**PROJECT# 1010205 - 15DRB-70110 MINOR - PRELIMINARY/ FINAL PLAT APPROVAL**

9. **Project# 1010205**  
15DRB-70110 MINOR - PRELIMINARY/  
FINAL PLAT APPROVAL  ARCH & PLAN LAND USE CONSULTANTS agent(s) for HPH FUND 1 D7 LLC request(s) the above action(s) for all or a portion of Block(s) 85-D, **PRINCESS JEANE ADDITION** zoned O-1, located on LOMAS BLVD BETWEEN BETTS ST AND MORRIS ST containing approximately 2.75 acre(s). (J-21) *[Deferred from 3/18/15, 3/25/15, 4/8/15]* **THE PRELIMINARY/FINAL PLAT WAS APPROVED WITH FINAL SIGN OFF DELEGATED TO TRANSPORTATION FOR PARKING SPACE COMMENTS AND TO PLANNING FOR REVISION OF EASEMENT GRANTING AND FOR ADDITIONAL COMMENTS.**

**CITY OF ALBUQUERQUE  
PLANNING DEPARTMENT  
March 18, 2015  
DRB Comments**

**PROJECT # 1010205            APPLICATION # 15-70110**

**PLAT OF
LOTS A AND B, BLOCK 85-D
DALE J. BELLAMAH'S PRINCESS JEANNE PARK**

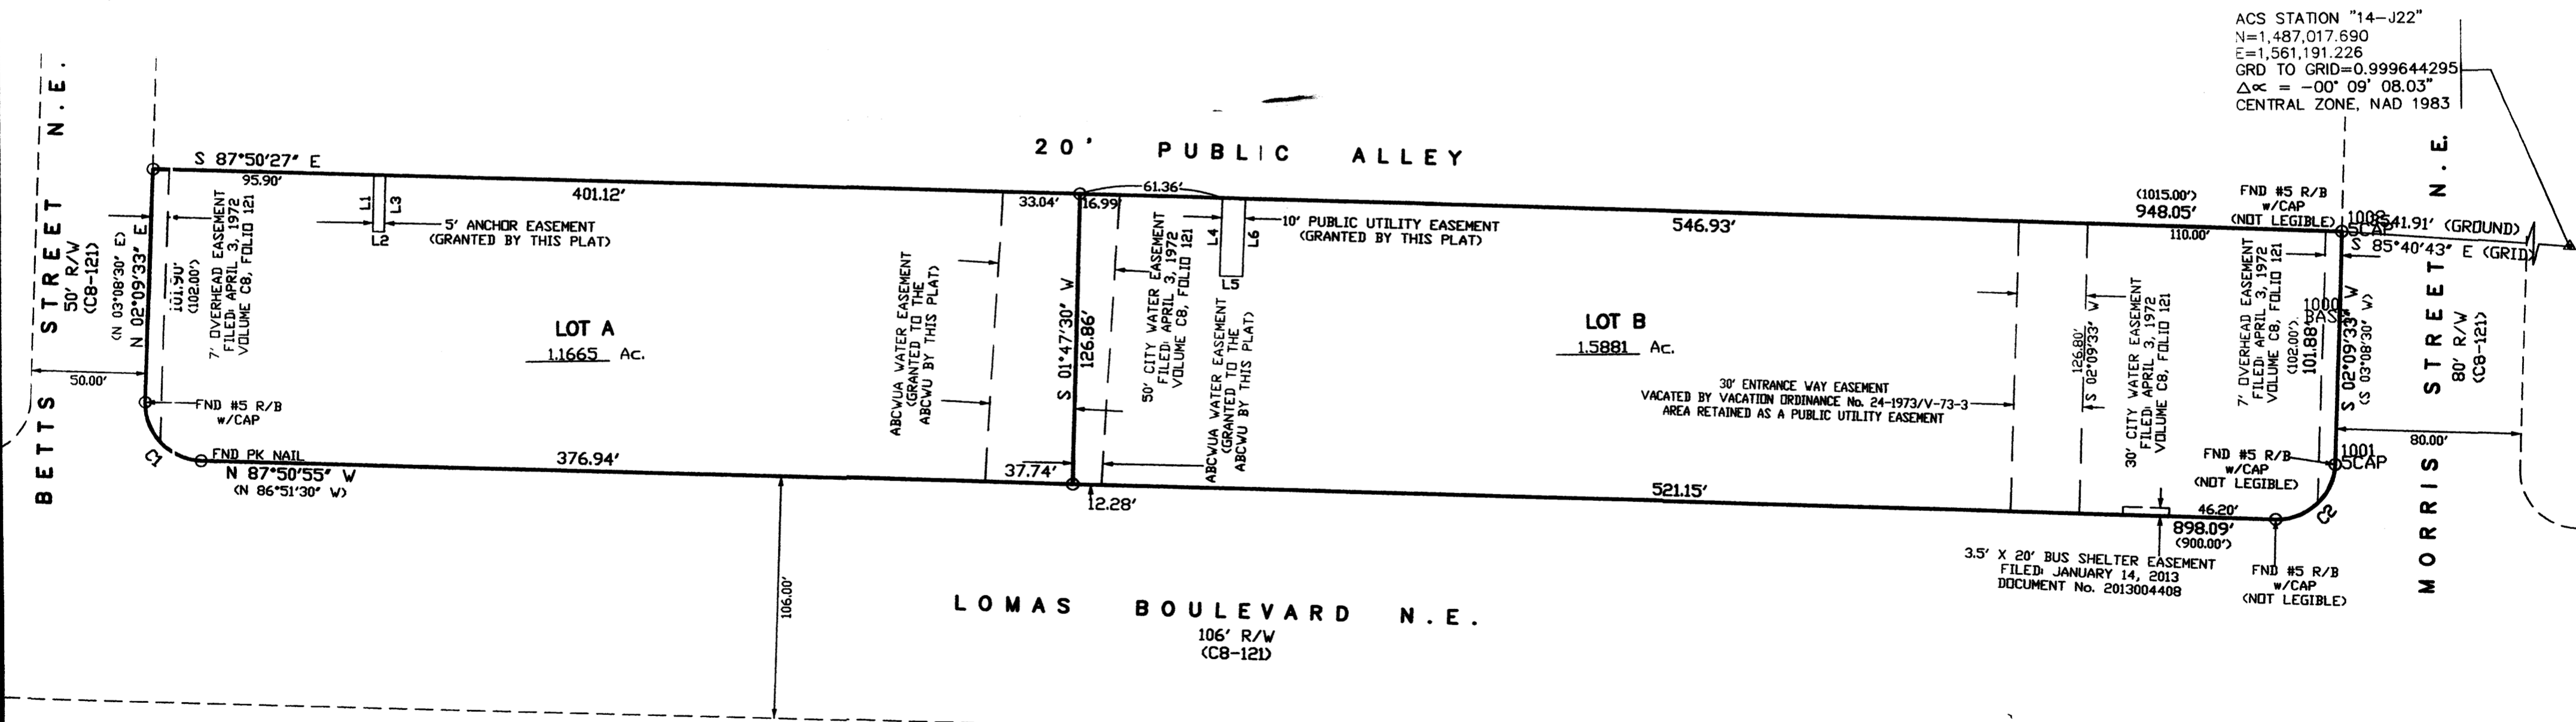
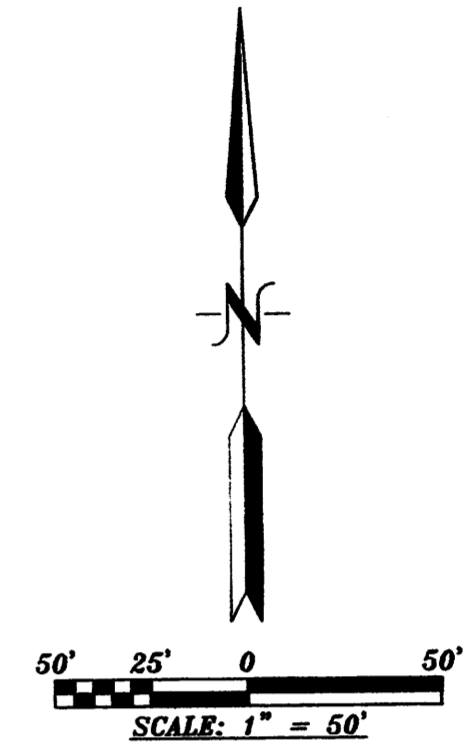
Per August 27, 2014 sketch comments, (Required) Parking calculations are needed – it appears neither of the proposed lots will conform with the on-site parking requirements of the Zoning Code, which means a Parking Variance would have to be approved prior to submitting for plat approval.

Additionally, it appears there are parking spaces encroaching into public right of way – refer to comments from Transportation Development.

Finally, it appears reciprocal parking easement may be needed depending on the location of the proposed lot line; refer to the Minor Subdivision checklist for a dimensioned site sketch.

Transportation Development has identified 3 parking spaces which will be removed as part of this process.

Albuquerque Bernalillo County Water Authority required the splitting of the existing water and/or sanitary sewer easement into two separate easements to reflect the containment entirely within a single lot. In addition, the activation of service for proposed Lot B.
